## **GORTYRAHILLY WIND DAC**

## **GORTYRAHILLY WIND FARM CO. CORK**

## **RESPONSE TO REQUEST FOR FURTHER** INFORMATION

# **AN BORD PLEANÁLA APPLICATION** REFERENCE ABP-314602-22

Job No.	Drawing no.	Revision
6225	6225-PL-100	A

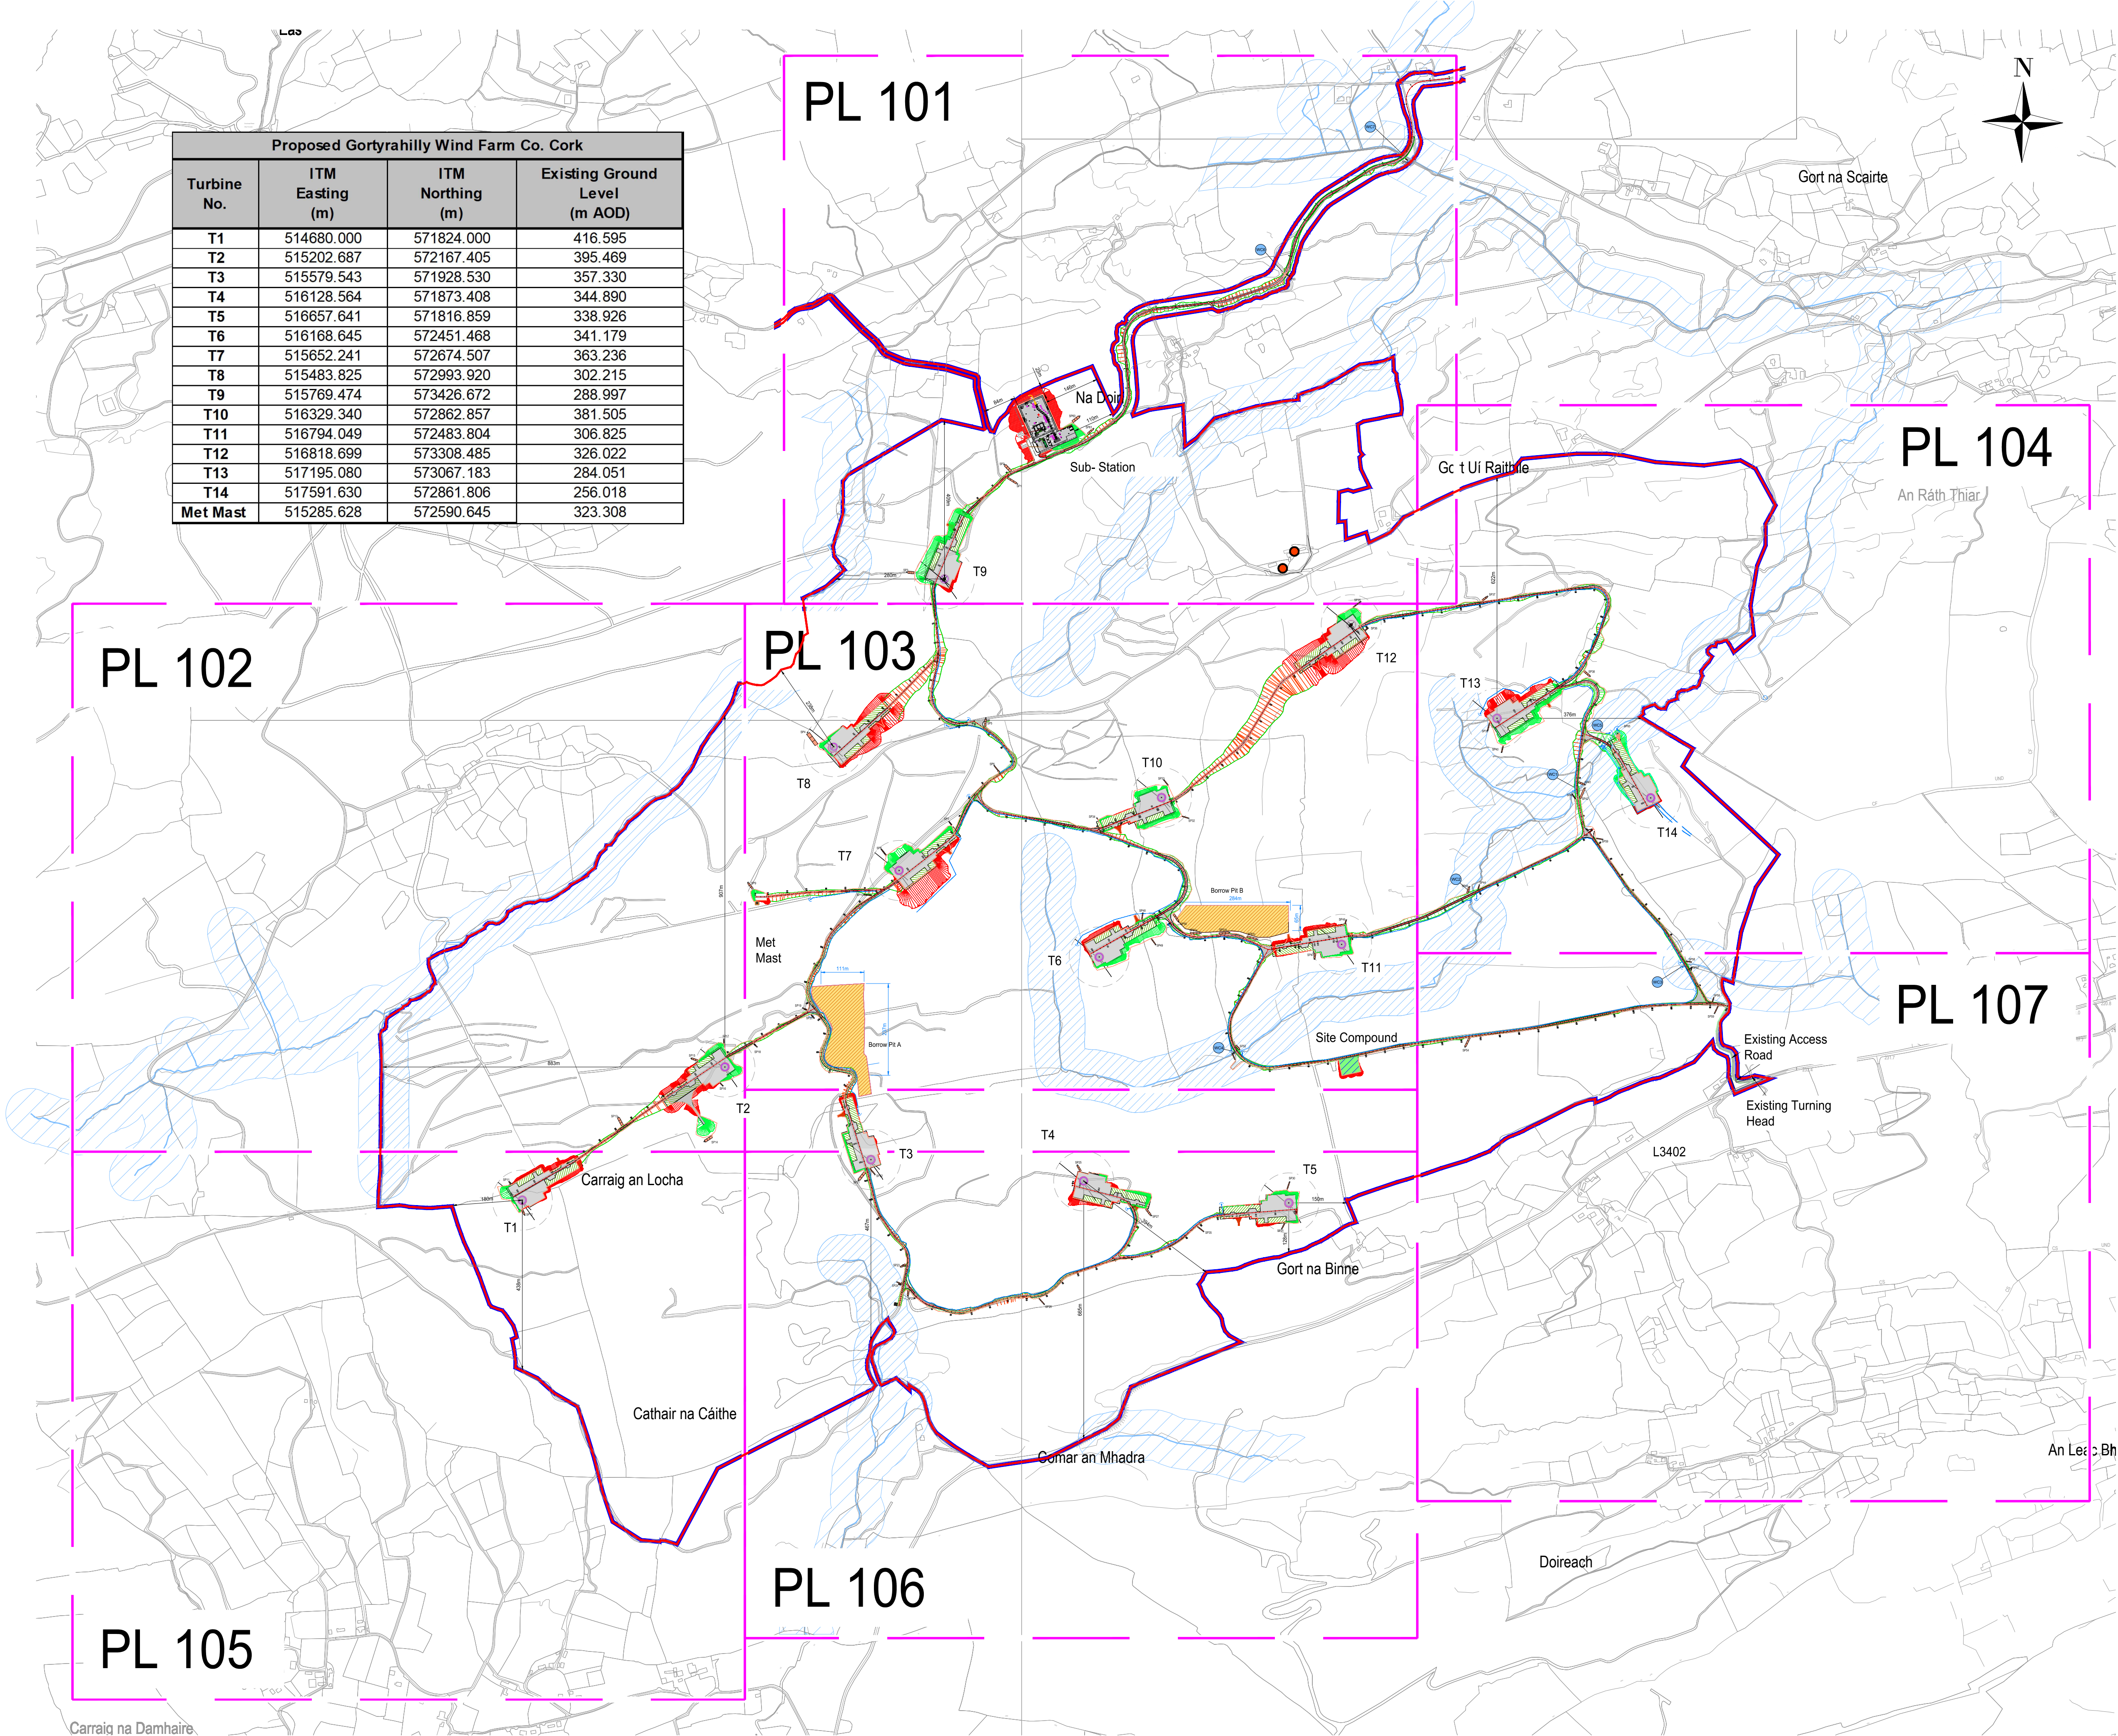
The Planning Statement and the Environmental Impact Assessment Report (EIAR) reference two residential buildings located 225m from T12. It is stated throughout the submitted documentation that should planning consent be given, these buildings will be in the control of the applicant and will not be inhabited for the operational period.

- (a) Identify the exact location of those dwellings on the Site Layout Key plan (Drawing No. 6225-PL-100).
- (b) Confirm if these dwellings are located within the red and/or blue line of the proposed application.
- (c) Provide letters of consent, and/or any other relevant information from the existing landowners agreeing to the information in the application.

(a) Revised Drawings for 6225-PL-100 and 6225-PL-101 have been included as Appendix A.

- (b) These properties are located within the red line of the proposed application.
- (c) Section 2.3.1 of the EIAR Chapter 2 states the following:

A letter of consent has been provided in **Appendix B** which has been agreed with and signed by the owner of the two residential buildings located 225m from T12 shown on Drawings 6225-PL-100-Rev A and 6225-PL-101-Rev A provided in Appendix A confirming that both buildings will be in control of the applicant and will not be inhabited for the operational period of the Development.
